# Rezoning Transportation Analysis

Petition Number: #2022-066

## Revision Log:

Date	Description
09-28-2022	First Review (AO)
10-26-2022	Second Review (IW)

RZ-2

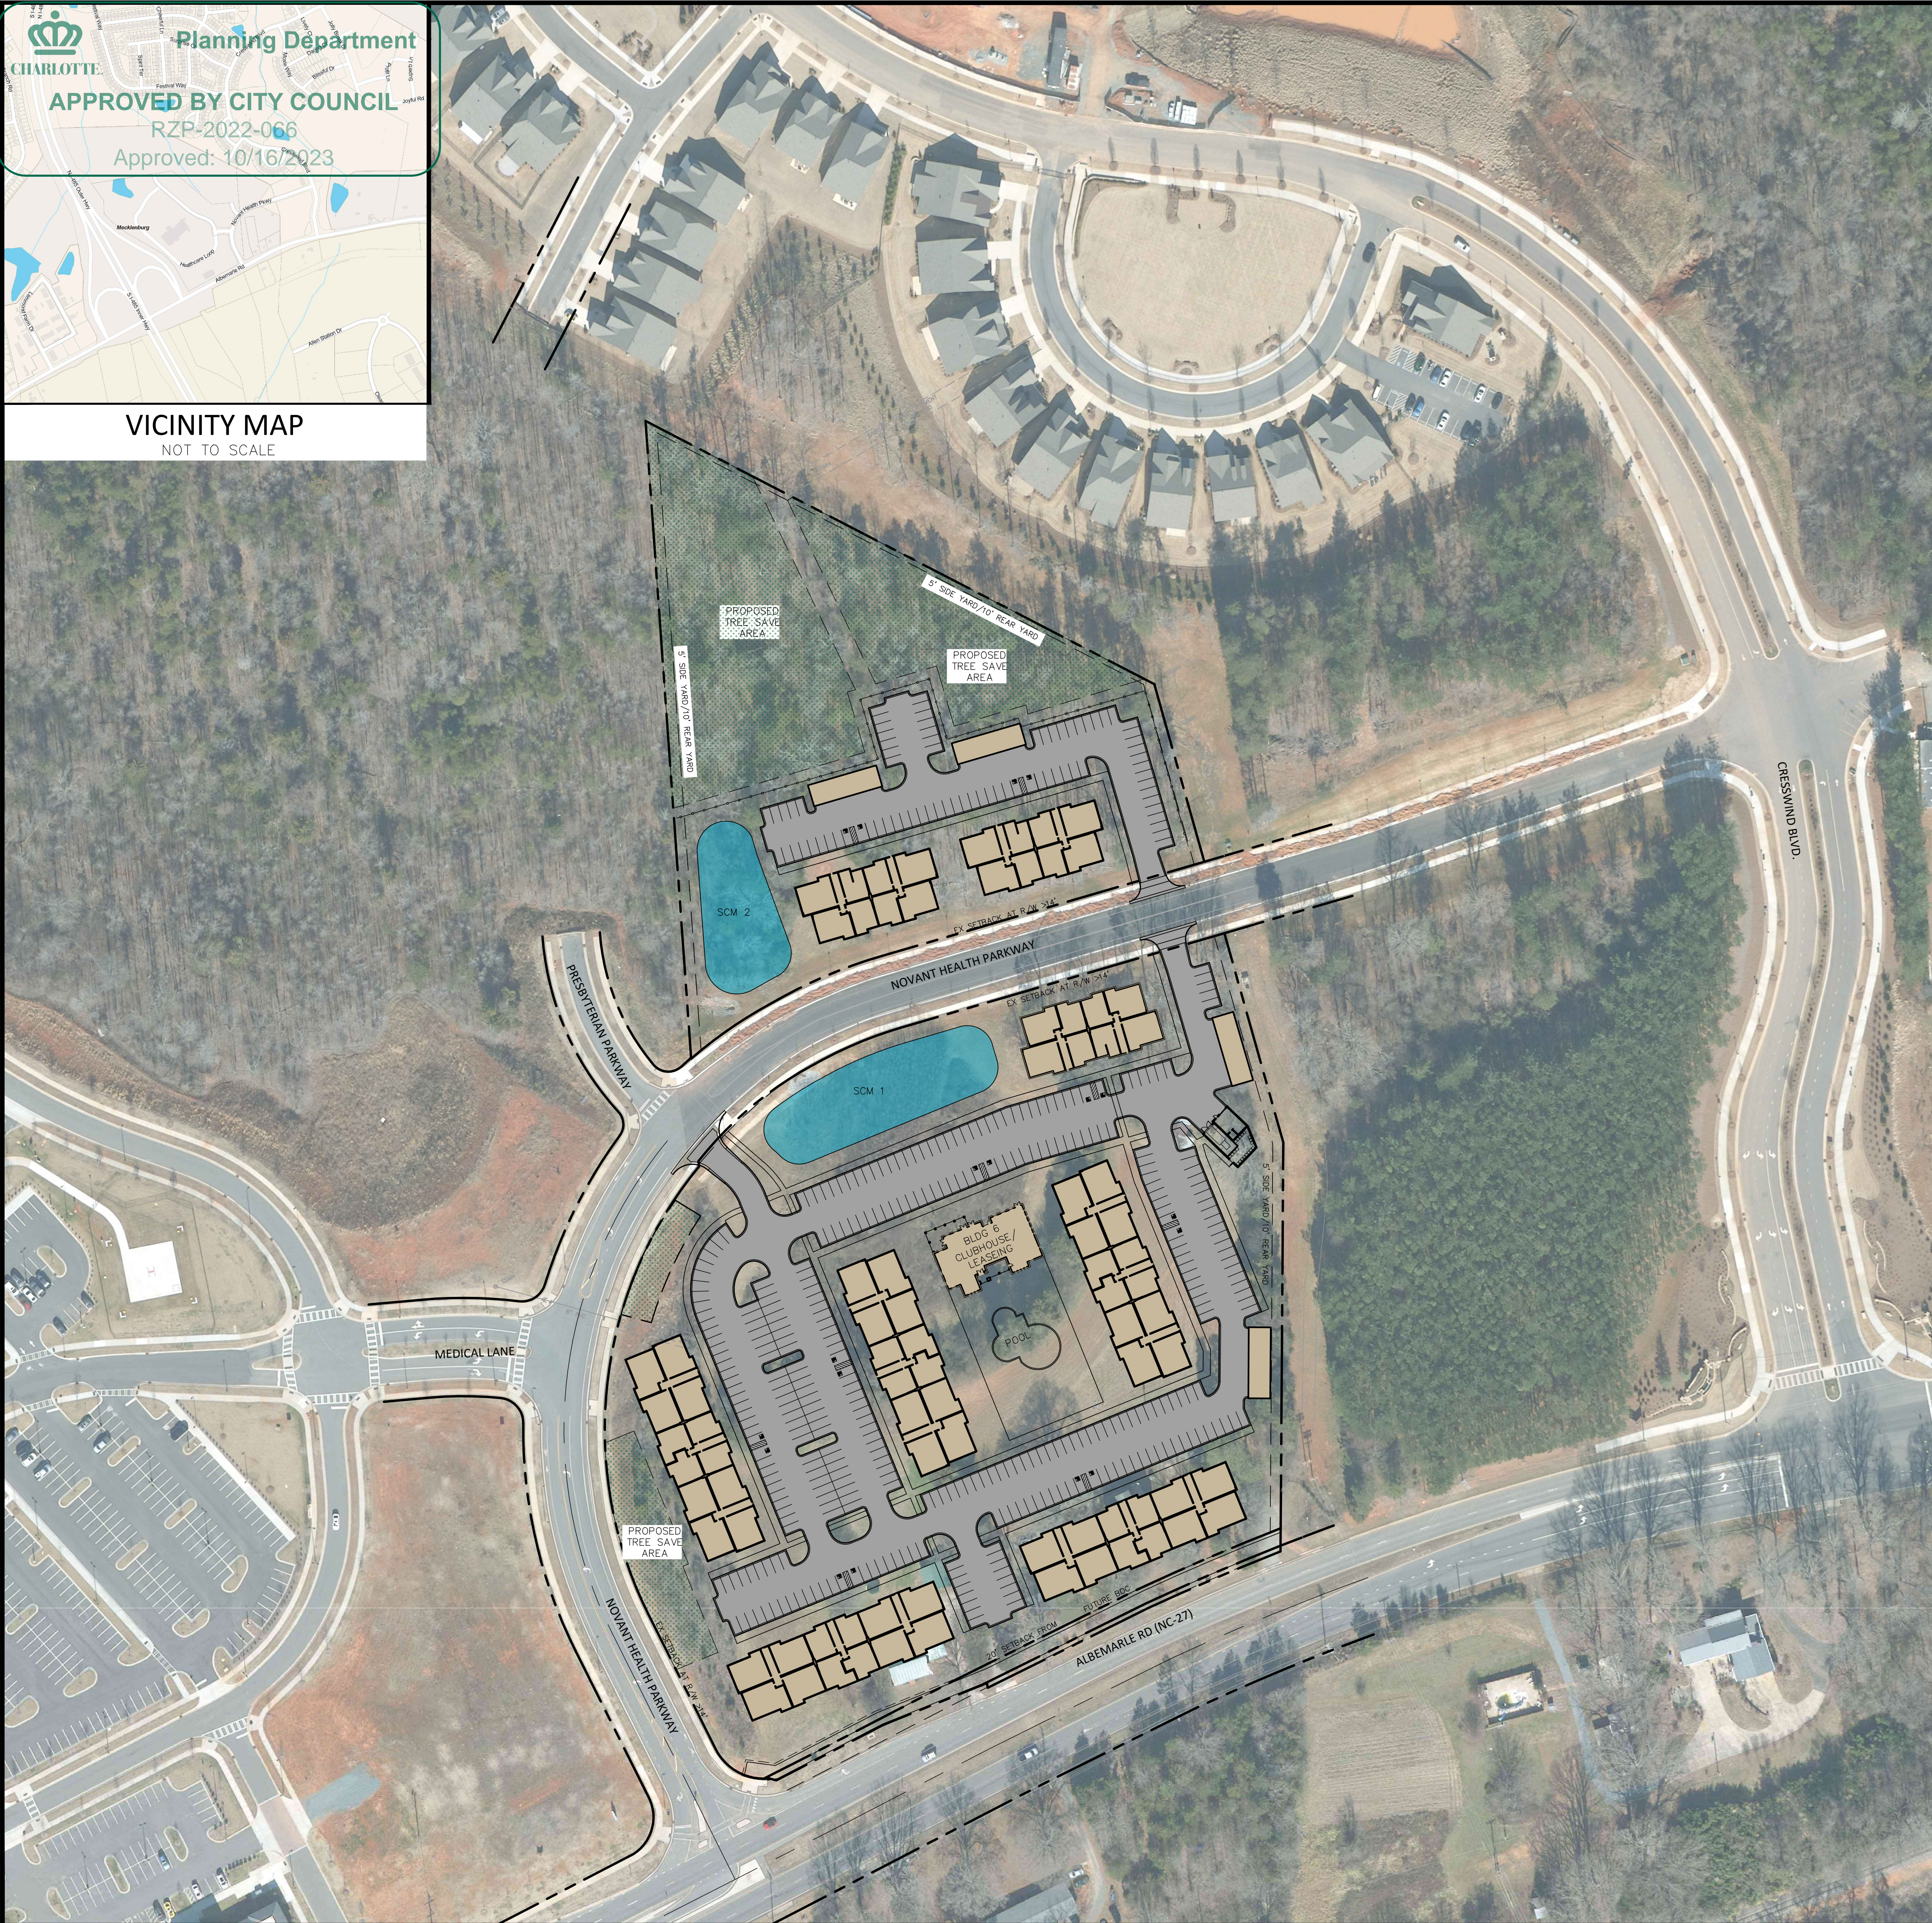
3. **Outstanding Comment from 09-28-2022** Revise site plan and conditional note(s) to commit to dedicate 100 feet of right-of-way or existing right-of-way, whichever is greater from the road centerline of Albemarle Road. The site plan shall label and dimension the right-of-way from the road centerline of Albermarle Road and Novant Health Parkway.
4. ~~Revise site plan to remove 35x35 sight triangle from the intersection of Albemarle Road at Novant Health Parkway. See advisory information regarding sight triangles.~~
